City of Albuquerque

RE: JUAN TABO AND LEXINGTON N.E. (FILE NO. H-22-D18)

SUBJECT: STANDARD BRANDS PAINT STORE ALLEY GRADES

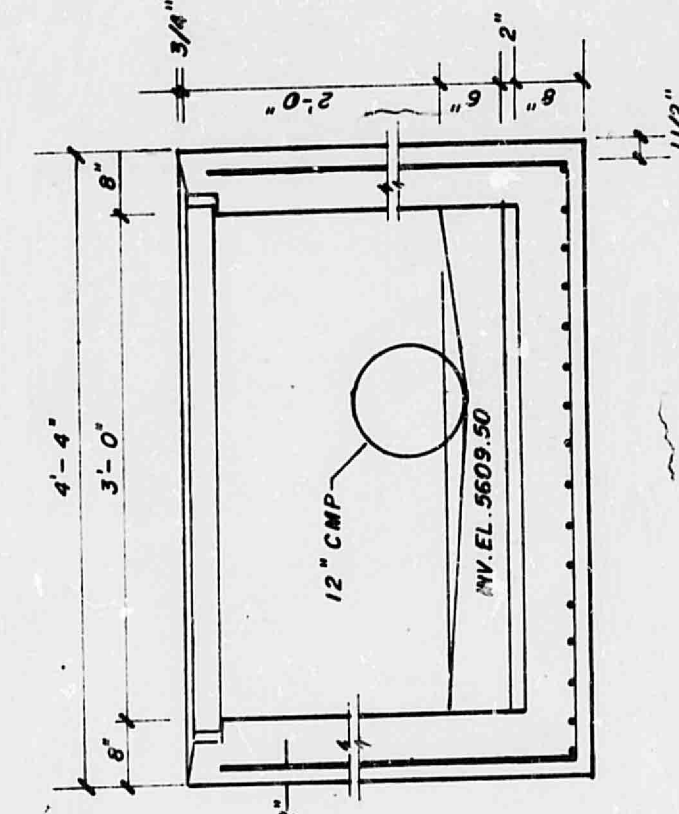
My biggest concern regarding the subject alley grades are the proposed grade changes along the alley's right-of-way and its impact on the adjacent tracts, i.e.: loss of access by the tract owners to their property, undermining of the retaining wall adjacent to the site and the need for retaining walls along the alley to absorb the difference in elevations. Also this plan does not indicate if the contours shown are proposed or existing.

① BREAK CANTOURE, HAVE FLOW
WILL DRAIN TO CUR. OF J. TABOAN
OLEX NGTON & ^{REMAINING} FLOW WILL DRAIN
TO CUR. OF JUAN TABO & ALLEY
USE DRAIN PLATE HERE ACROSS SIDEWALK

② SHOW ADJ. PROPERTY FINISHED
GRADES
